## SMELKER-HCI

NEW BUILDING  
7920 INDUSTRY ROAD  
COLORADO SPRINGS, CO 80934  
EL PASO COUNTY, COLORADO

**1 SITE PLAN**  
SCALE: 1"=20'-0"

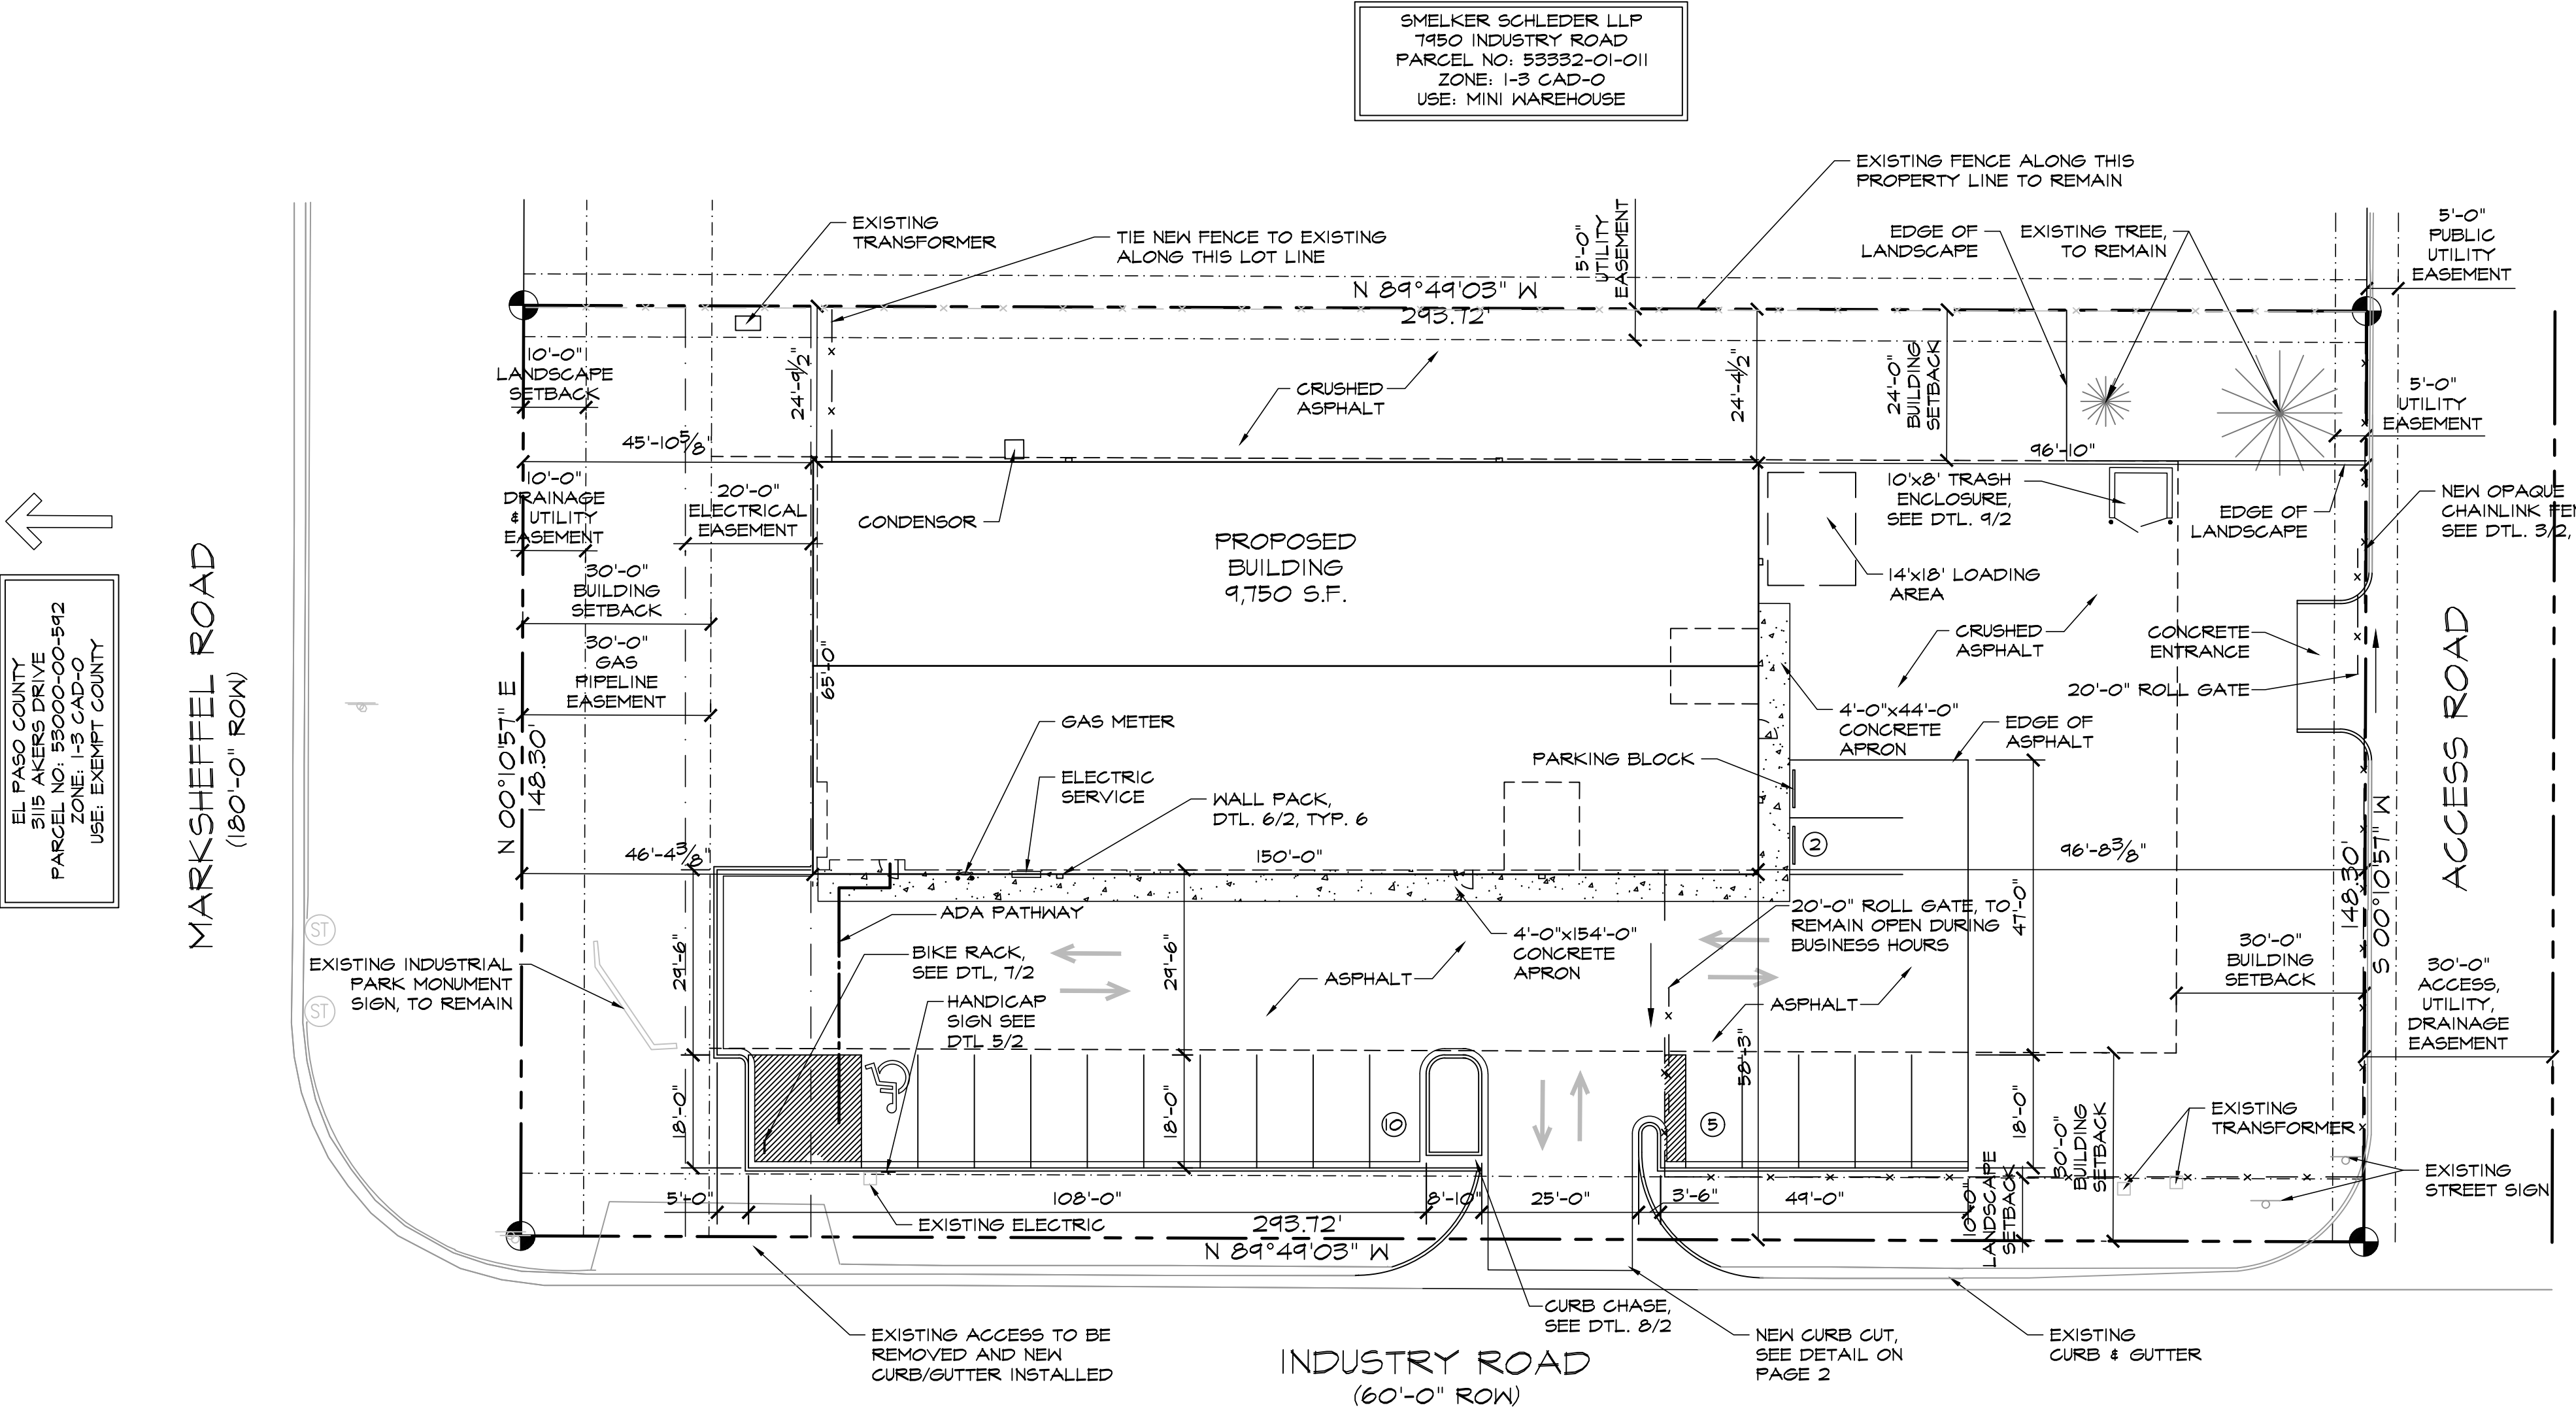
Please include:  
-location of existing and proposed water/waste water infrastructure, if none please specify  
-location of no build areas, flood plans, or drainage facilities, if none please specify

Please provide LxWxH of all signage

Please provide height of all fencing/gates shown in the site plan

Please include high and intensity of lighting
